2A Gregory Place Pty Ltd

RE: RESPONSE TO DEVELOPMENT APPLICATION, SSD-31179510

Horticultural Management Services prepared the updated Arboricultural Impact Assessment, Tree Protection and Management Plan on behalf of 2A Gregory Place Pty Ltd to accompany the submitted Assessment Report for the proposed Affordable Housing and Build to Rent State Significant Development Application, SSD-31179510.

6.1.5 Tree Retention & Removal

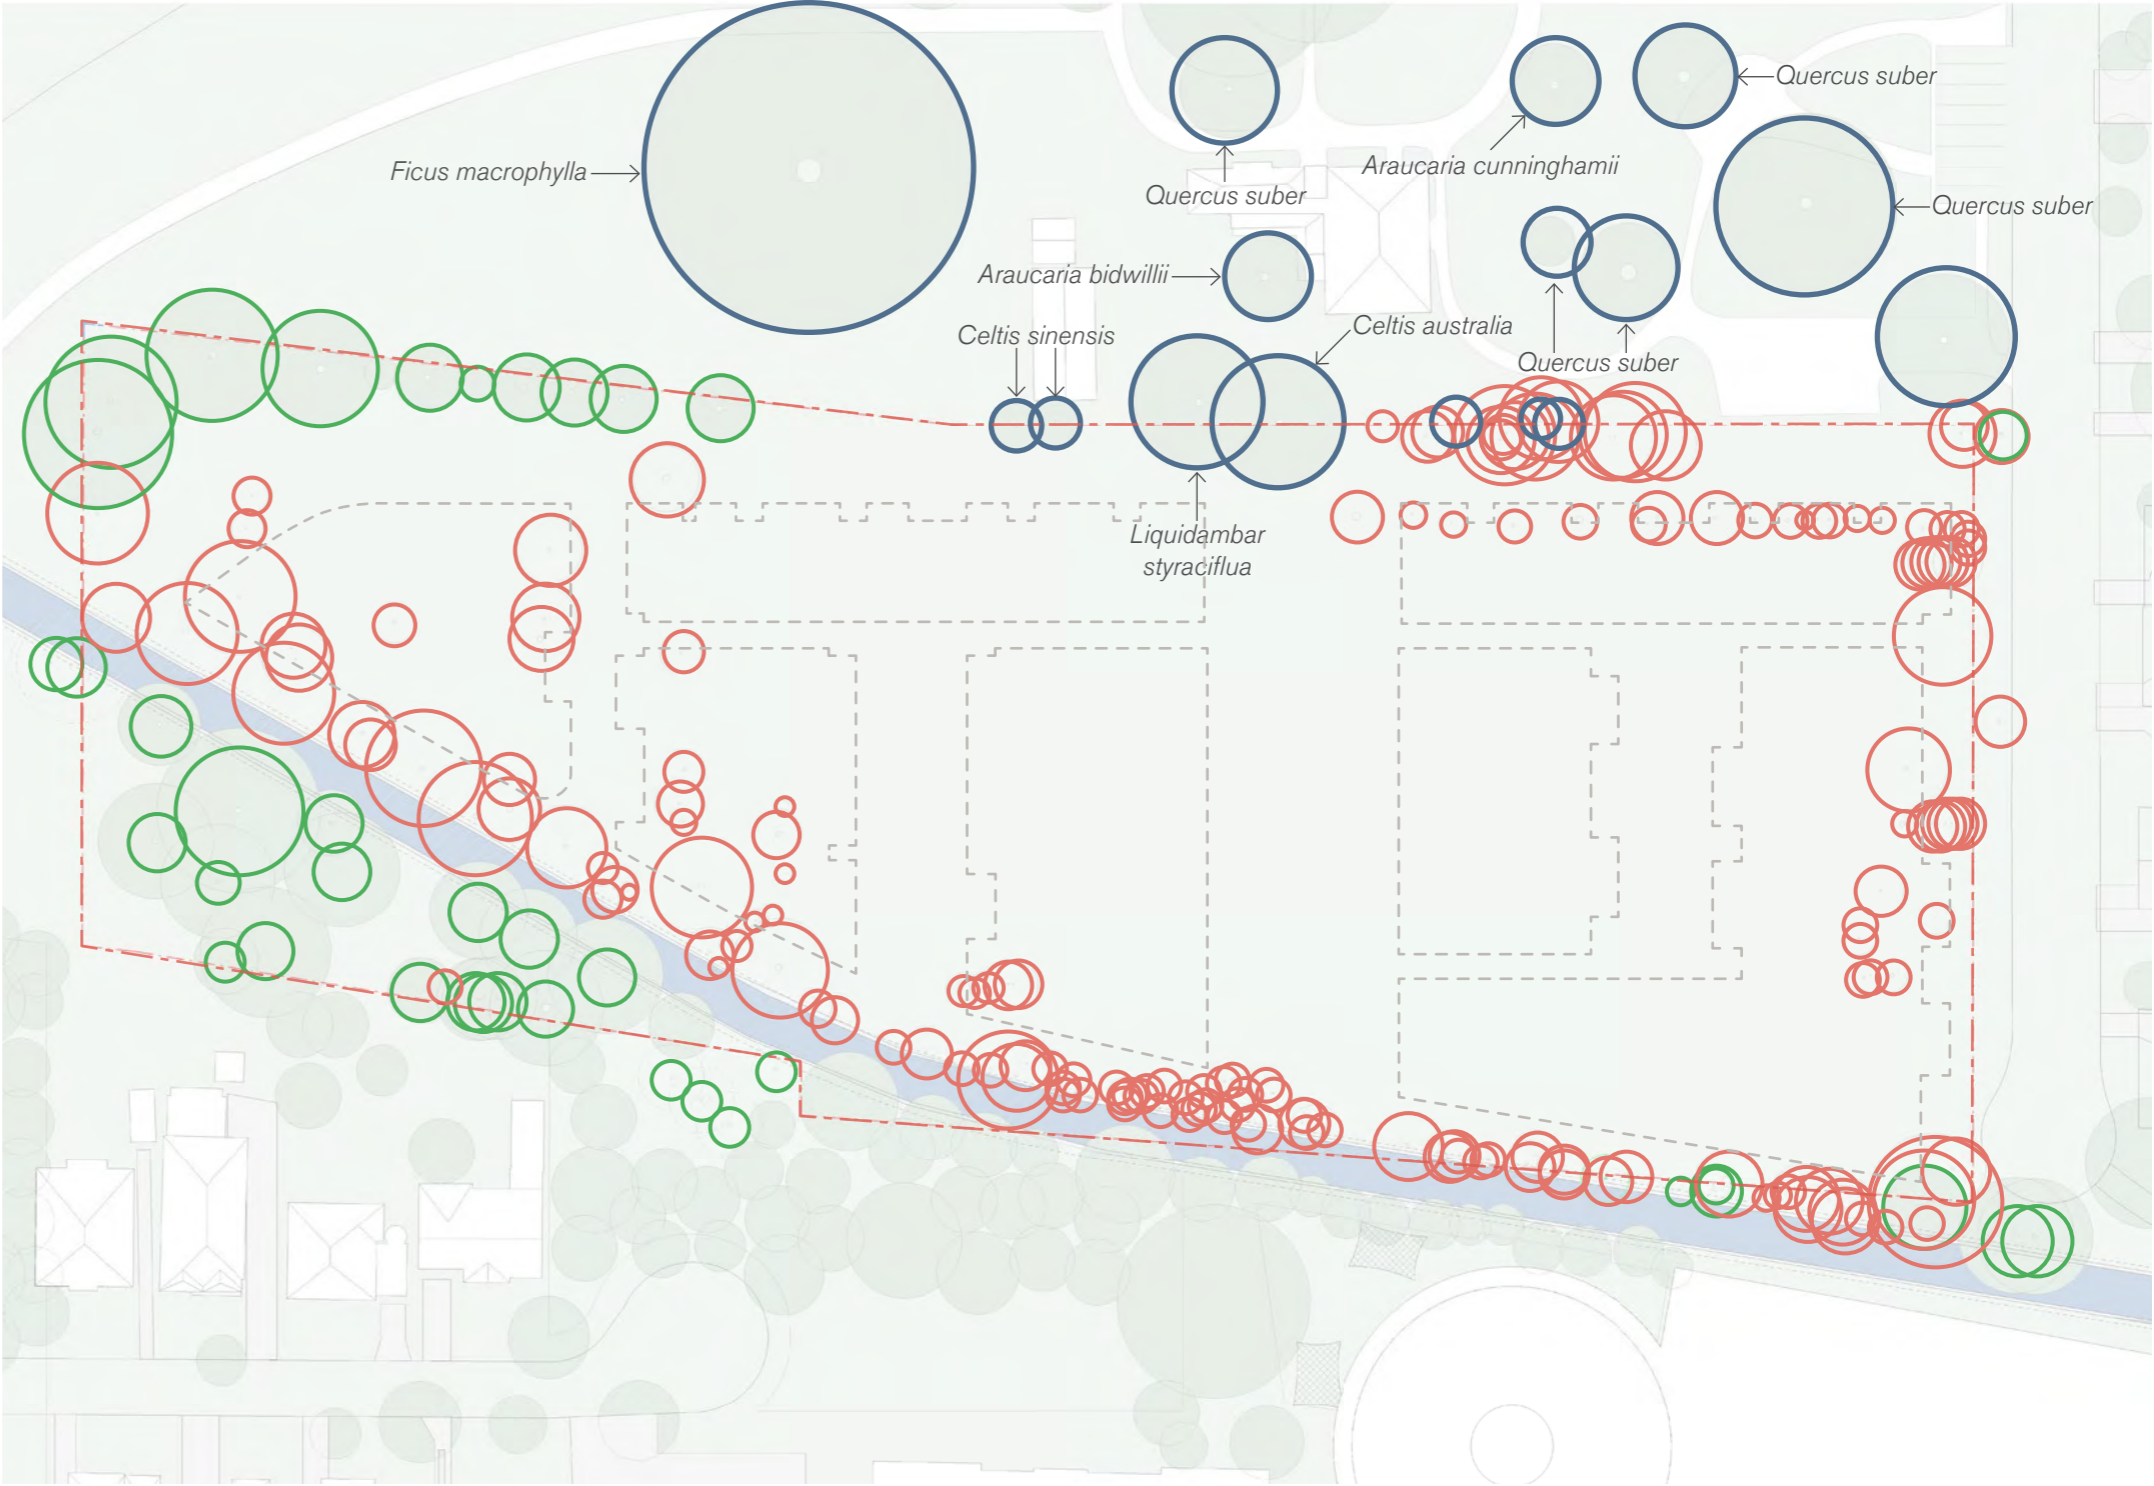
<i>Council raised concerns in its previous submission in relation to inadequate setback given to significant trees T181, 190, 191 and 192 located within the northwestern corner of the site. The design has been revised to provided adequate setback to the proposed buildings.</i> <i>The area surrounding the trees has since been replaced with a cul-de-sac road configuration which appears sufficiently setback subject to confirmation at final design stage.</i>	Noted.
Recommendation: <i>It is recommended that DPHI draft a condition on any consent requiring that any future application(s) must submit a revised Arborist Report which specifies tree protection measures and setbacks to retain and protect trees across the site, including the abovementioned.</i>	Noted.
